Arun District Council
Arun Civic Centre
Maltravers Road
Littlehampton
West Sussex BN17 5LF
Planning & Building Control General Enquiries
Tel: (01903) 737756 Fax: (01903) 730442
Dx: 57406 Littlehampton
Minicom: 01903 732765
e-mail: planning@arun.gov.uk
website: www.arun.gov.uk/planning

Application No: AW/159/21/HH
Site Address: 25 The Drive Aldwick PO21 4DU
Description of works: Loft extension with 3 x rear dormers. This application affects the setting of the Craigwell House Conservation Area.

Thank you for your internet representation made on 30th May 2021 which has been recorded as an objection with the comments as follows:

Drawing number
AP/25/21/01

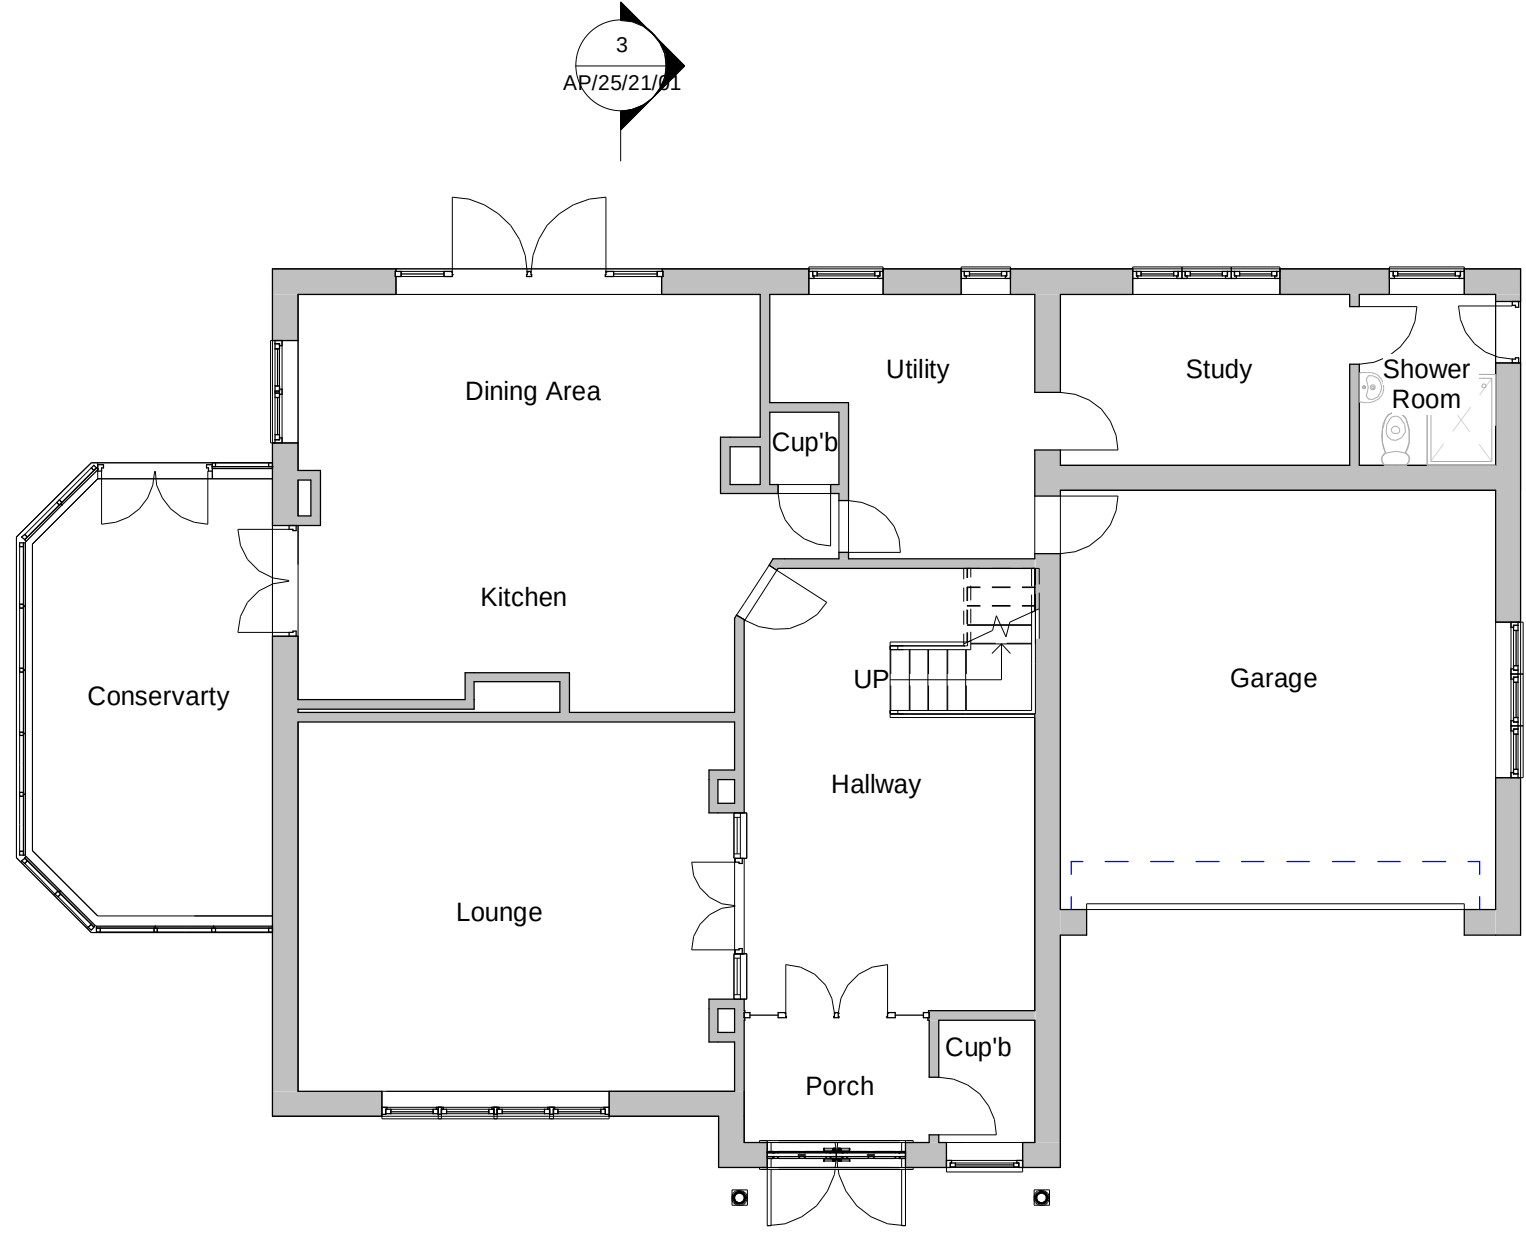
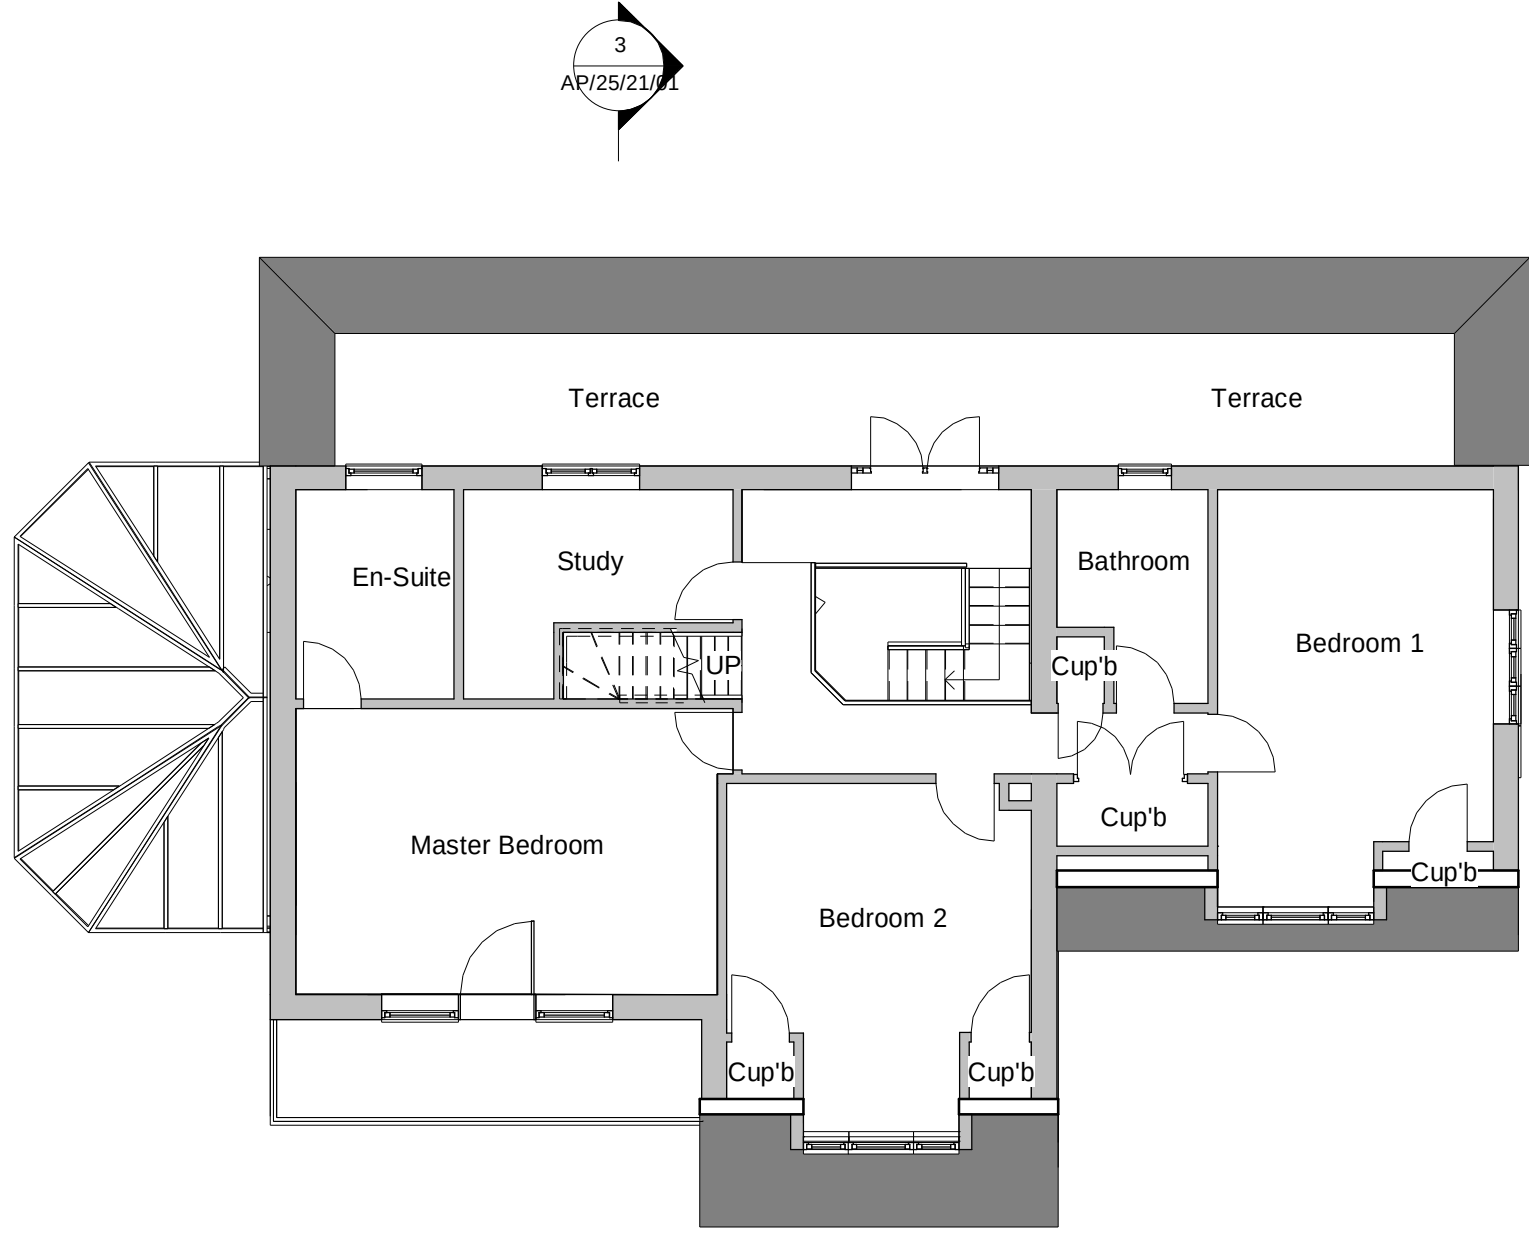
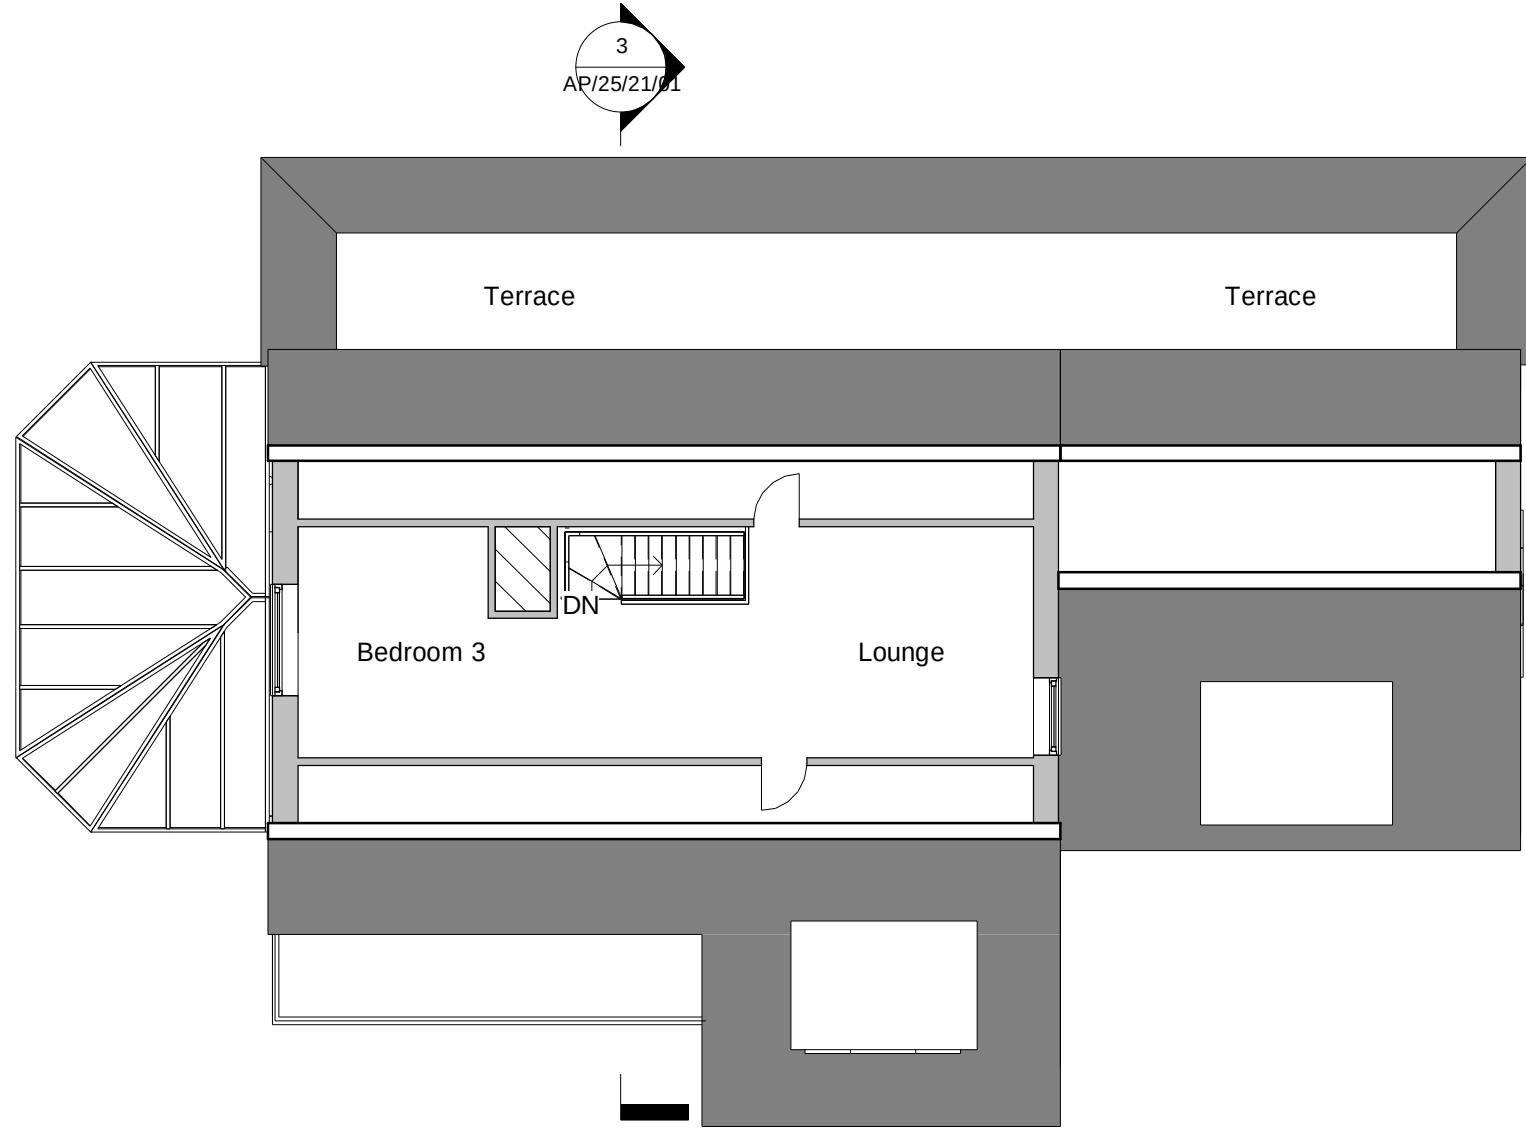
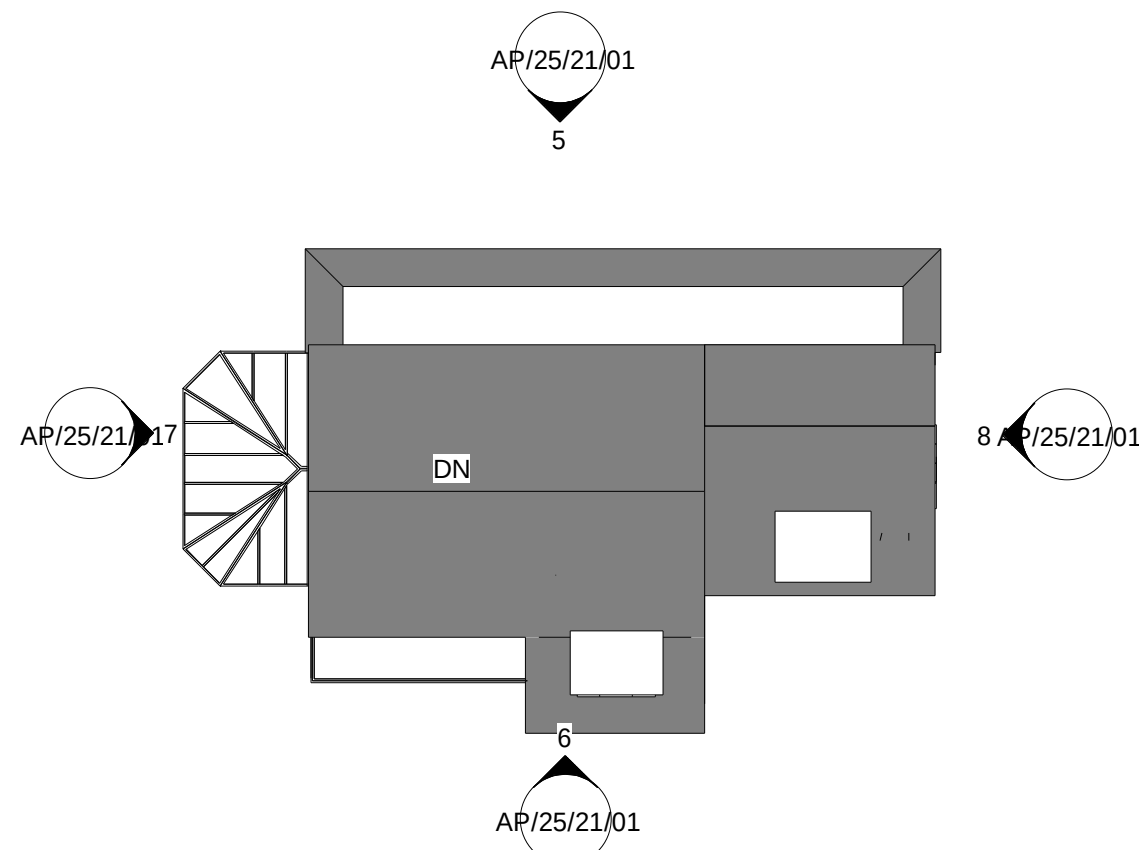
The existing plans AP/25/21/01, Rear Elevation (North) do not represent the current building. The work to complete planning application (AW/331/20/HH) deviated from the plans approved. In principle I do not have a problem with the changes made however there are now rear opening doors in the extension built and not represented on the existing plans submitted AP/25/21/01, so I question how a decision on planning permission can be made with inaccurate base information.
